**RE: KINESIO Headquarters
4001 Masthead St. NE
Requested for Permanent C. O. - Accepted
Engineers Stamp Date 2/5/16 (D17D103)
Certification dated: 8-15-16**

RE: KINESIO Headquarters
4001 Masthead St. NE
Requested for 30-day Temporary C. O. - Accepted
Engineers Stamp Date 2/5/16 (D17D103)
Certification dated: 8-15-16

**RE: Kinesio Headquarters
Grading and Drainage Plan
Engineers Stamp Date 2/5/16 (D17-D103)**

**RE: Kinesio Headquarters
Grading and Drainage Plan
Engineer's Stamp Date 11-30-2015 (File: D17D103)**

date  
**11-30-15**  
 sheet  
**C101**

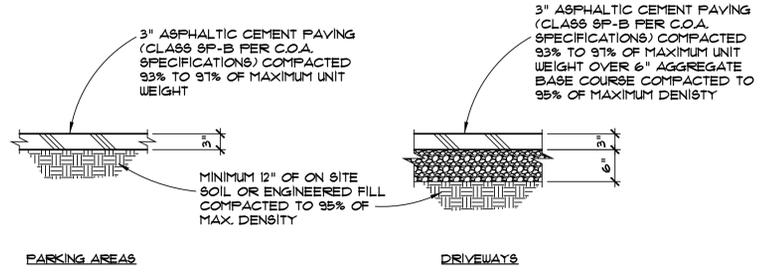
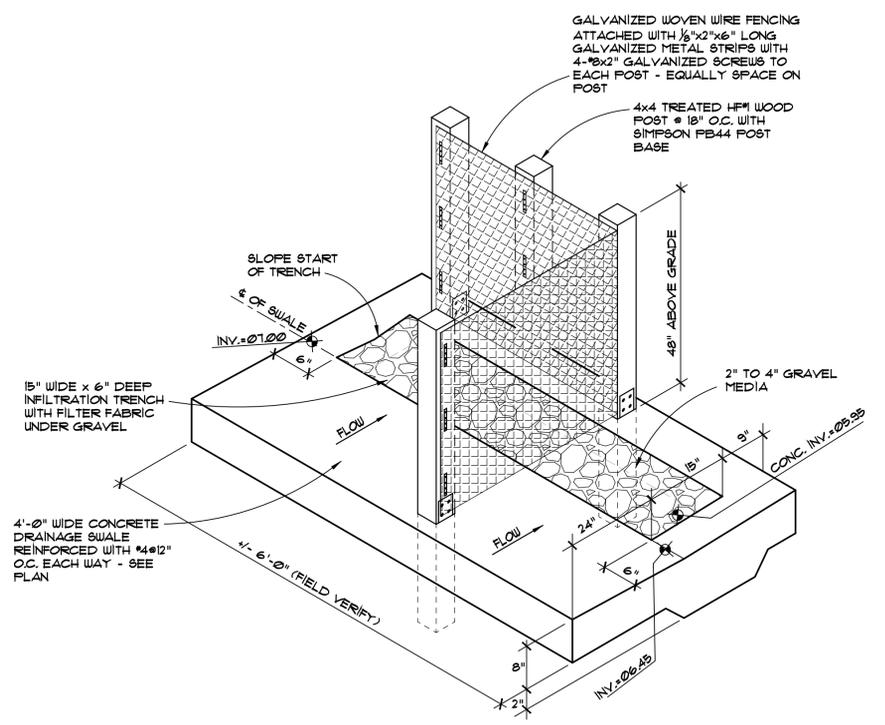
1. We understand that the license agreement with AMAFCA is in progress for the drainage outlet onto their Right of Way. Concurrence that the license agreement is completed (or that it will be completed) will be needed. Provide a calculation of the capacity of the outlet opening/structure to show that the peak flow of the pond is controlled.
2. Provide a capacity vs required flow calculation for the rundown just downstream of the last roof drain to show that the peak flow is contained in the structure.
3. Beginning January 15th, 2016, the City will amend the standard city street section (std drawing 2405A and B) to include a depressed landscape buffer between the sidewalk and back of curb. We request that you consider implementing this detail for the landscape buffer on the Masthead Street frontage.

GRADING AND DRAINAGE PLAN

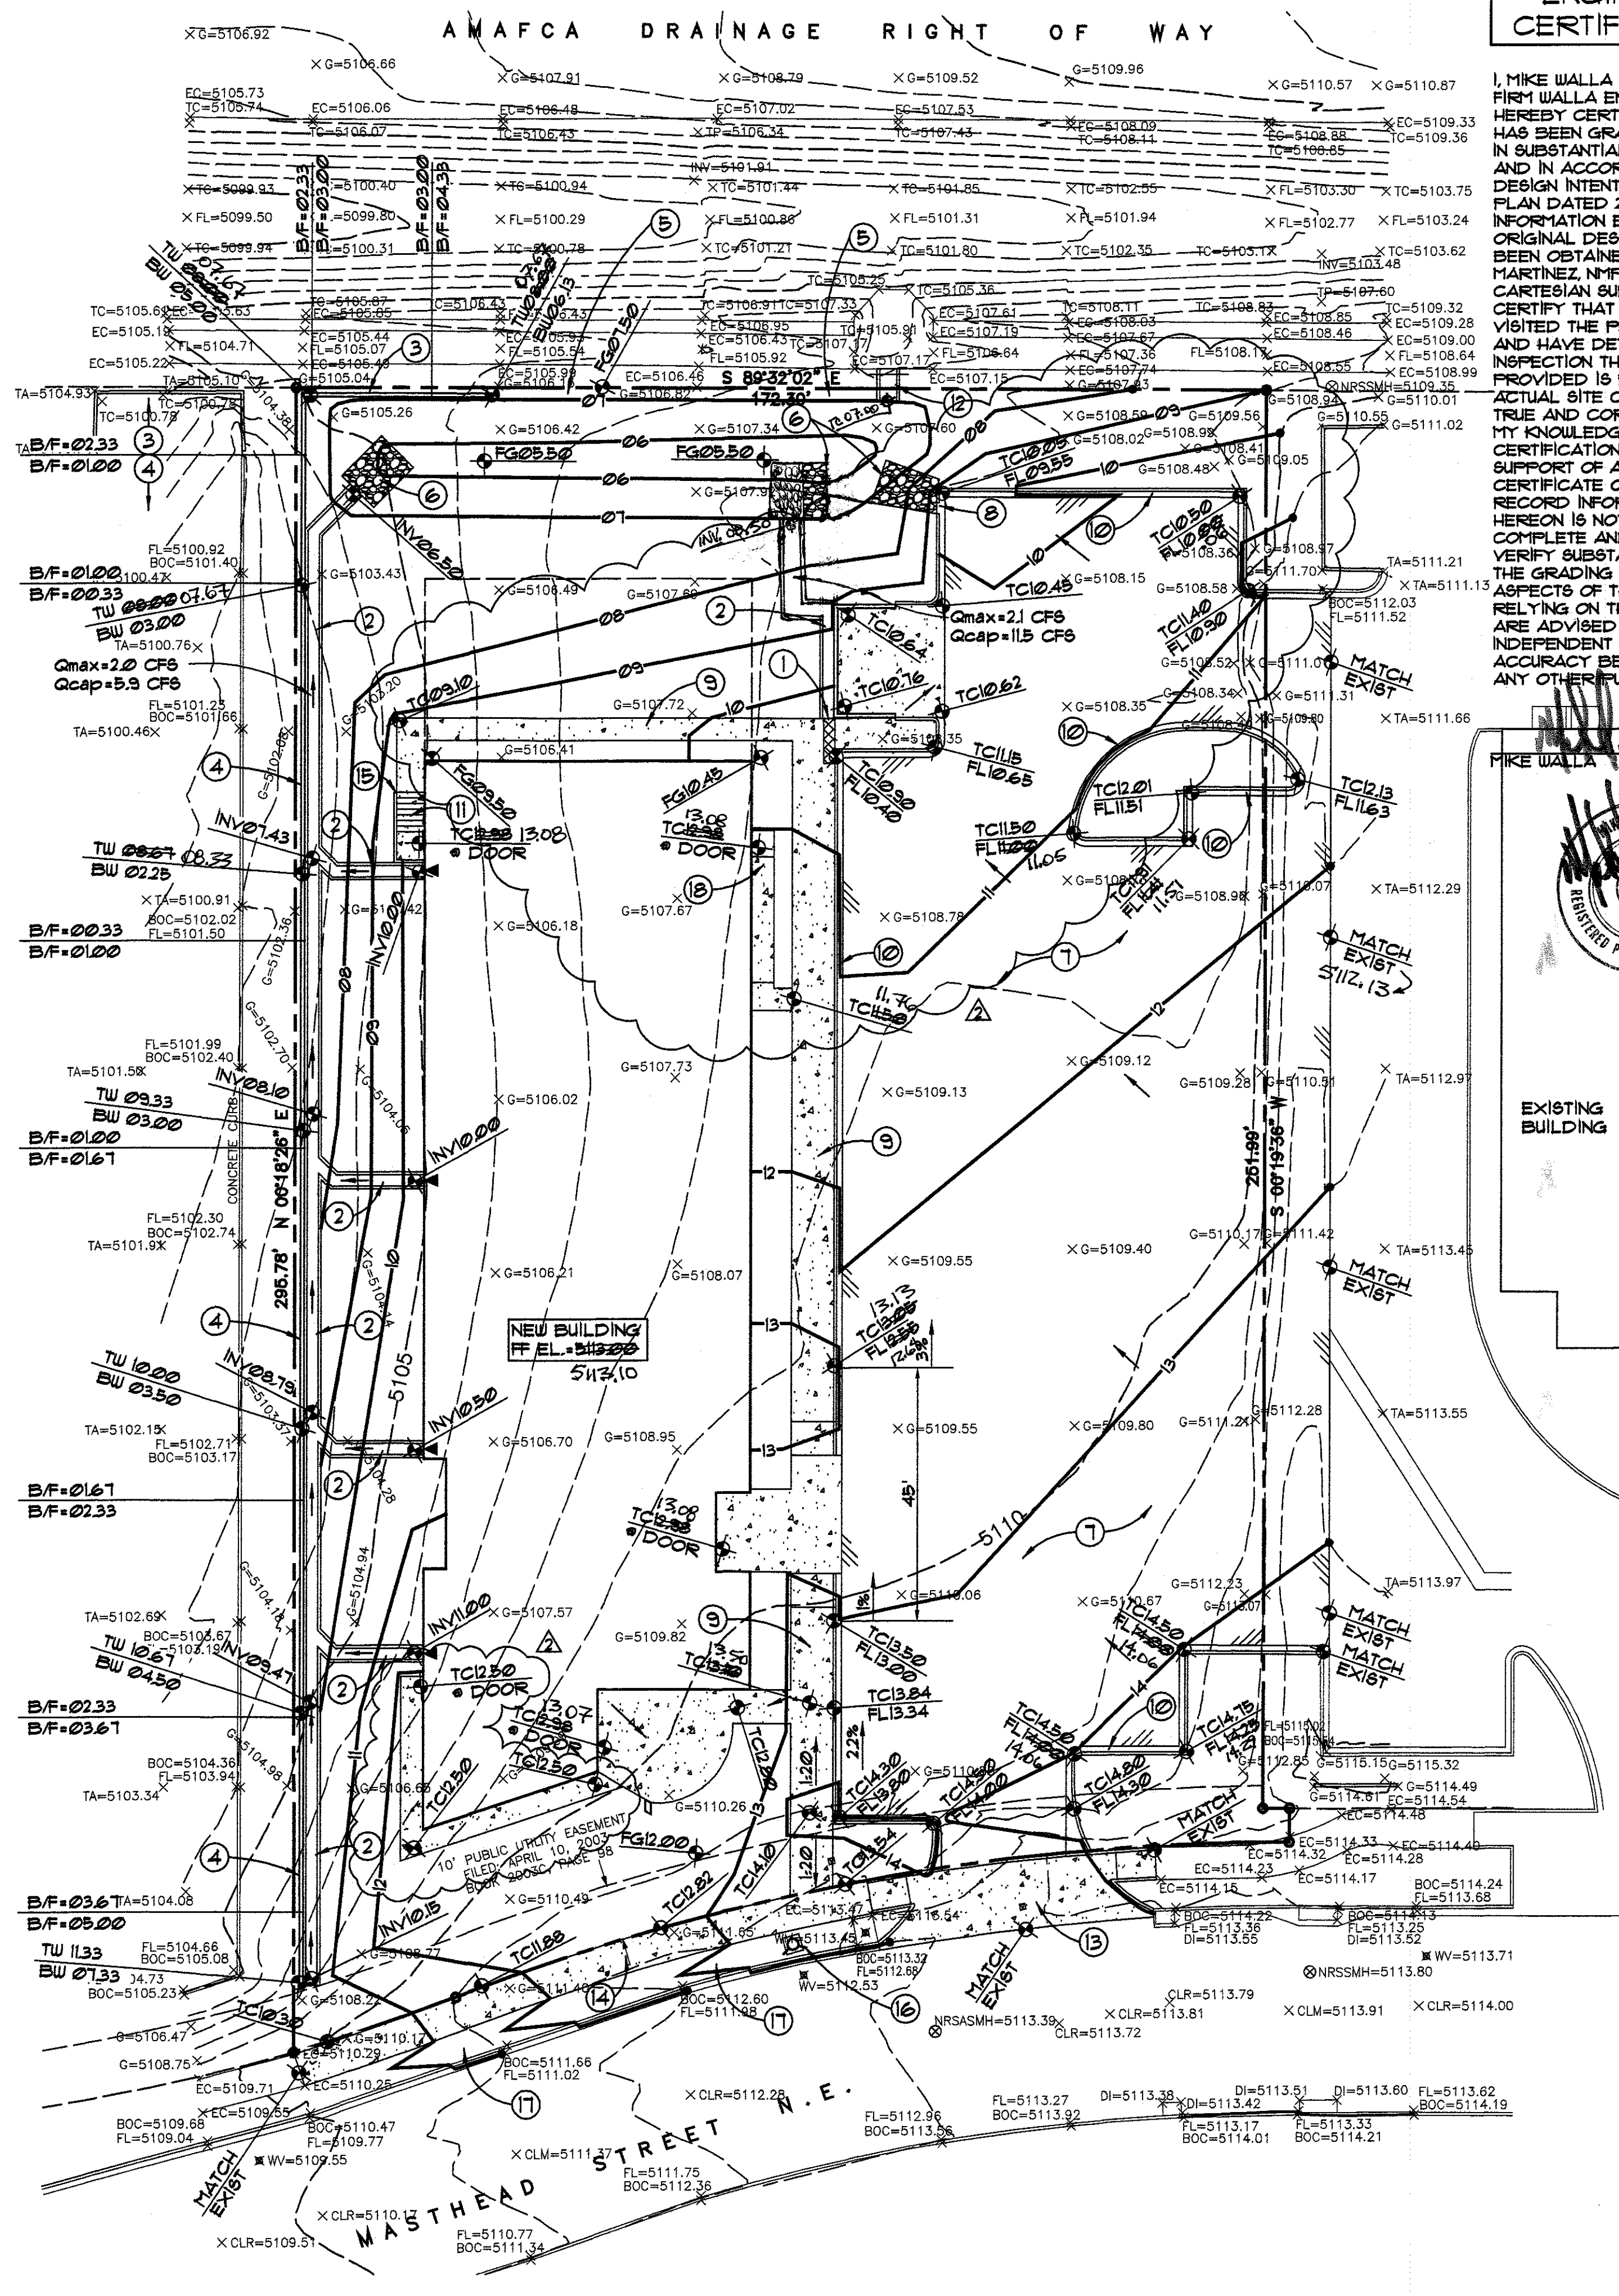
- The swale that fronts the property needs to be put in place.
- The transition between this property and the adjacent property to the west should be revised. The swaddle should be moved to the adjacent property. In its place fractured rock should be placed so any spillage from the 2' concrete rundown will overflow on top of the fractured rock prior to draining on to the swaddle.
